## MEMORANDUM

**CCES Responses 11-9-23**

SUBJECT: SF-22-041 – Retreat at TimberRidge Filing No. 3  
Second Submittal

RETREAT AT TIMBERIDGE FILING NO. 3 CONSTRUCTION PLANS UTILITY SERVICE PLAN			
DESIGNED BY	PRA	SCALE	DATE 12-8-2022
DRAWN BY	PRA	(H) 1" = 60'	SHEET 6 OF 7
CHECKED BY		(V) 1" = N/A	JOB NO. 1185.30

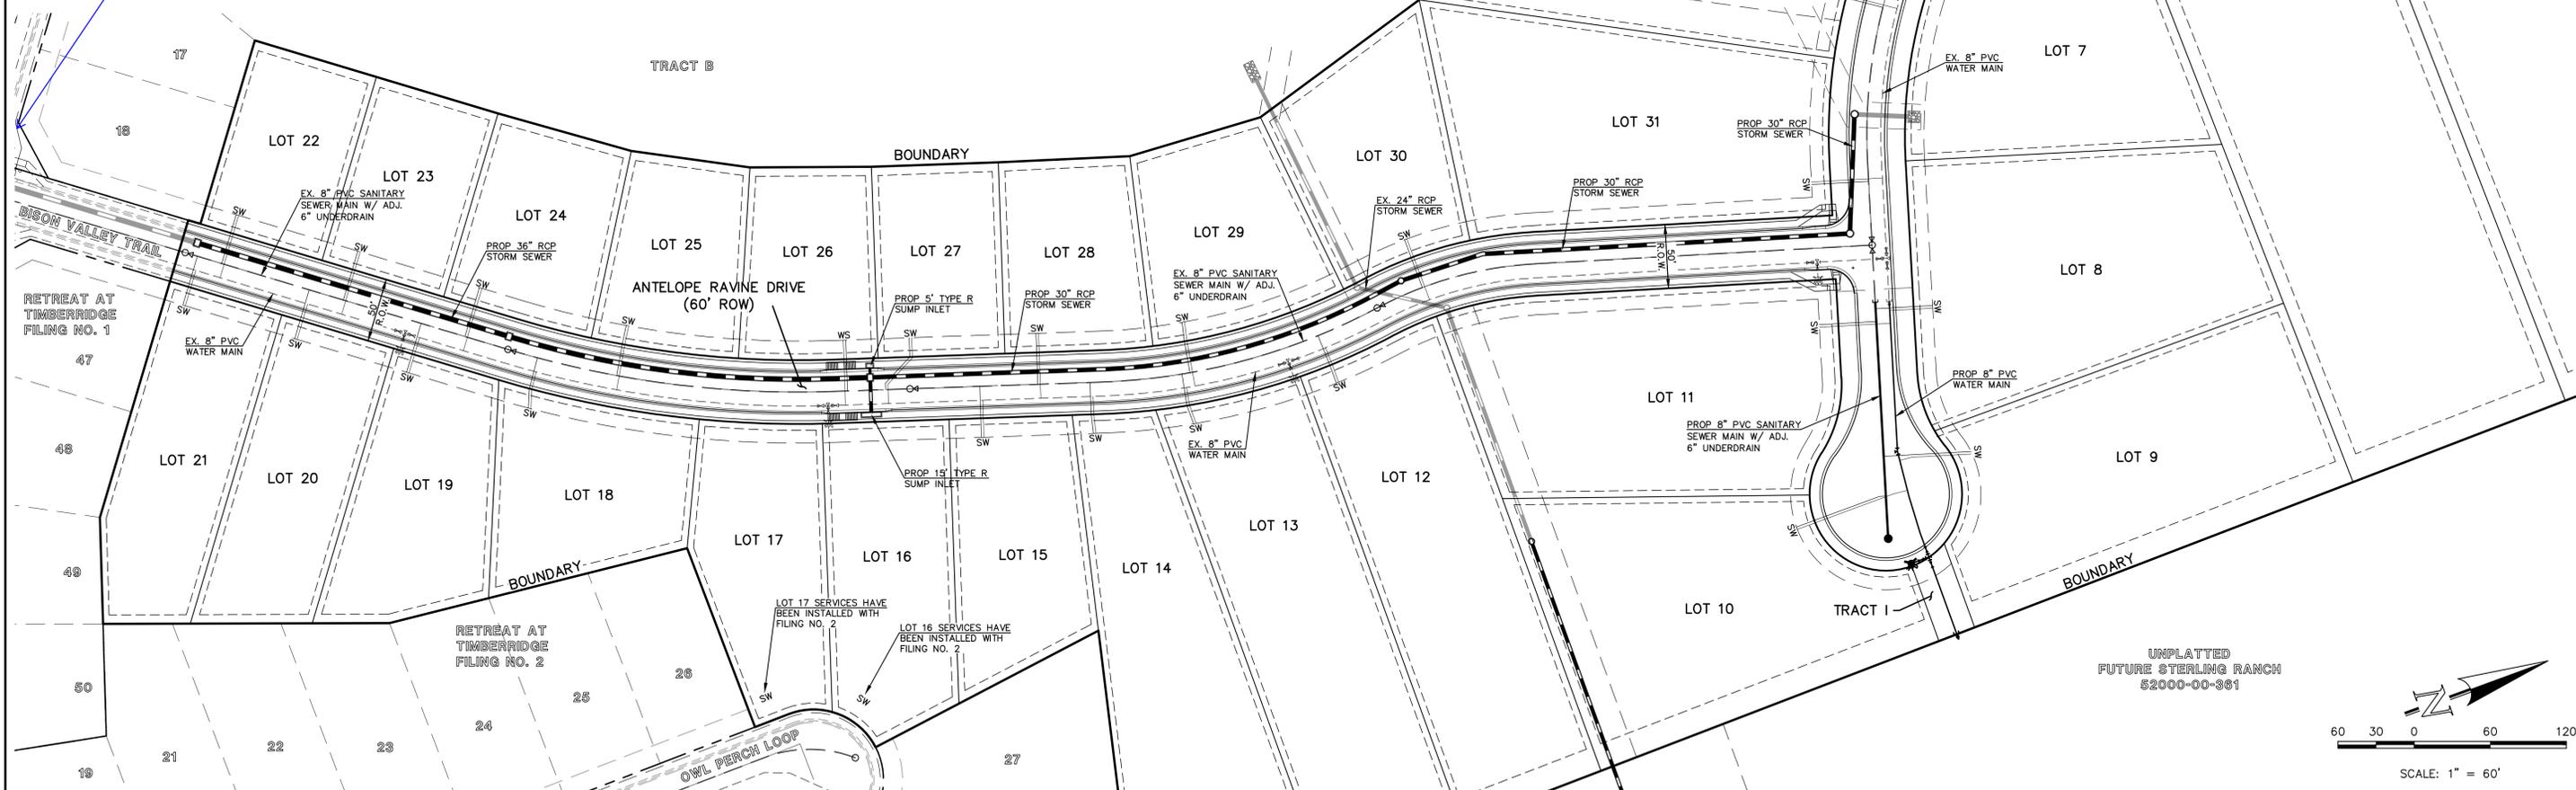
1. See CD/GEC redlines.
2. Provide the County CD signature block on the separate utility plans. Show the underdrain stub locations on the utility service locations details and note and/or show the underdrain system outfall(s) on the CDs. (Revise plat notes and provide a sump pump outlet plan for lots on urban roads if not proposed.) **Unresolved 6" underdrain installed adjacent to all San. Sew. Mains. Lot foundation drains will connect to these. Locations now shown on util. plans.**
3. Note: a pavement design report is required to be approved prior to base course installation.
4. Note: Bridge material design life certifications will be required prior to acceptance.
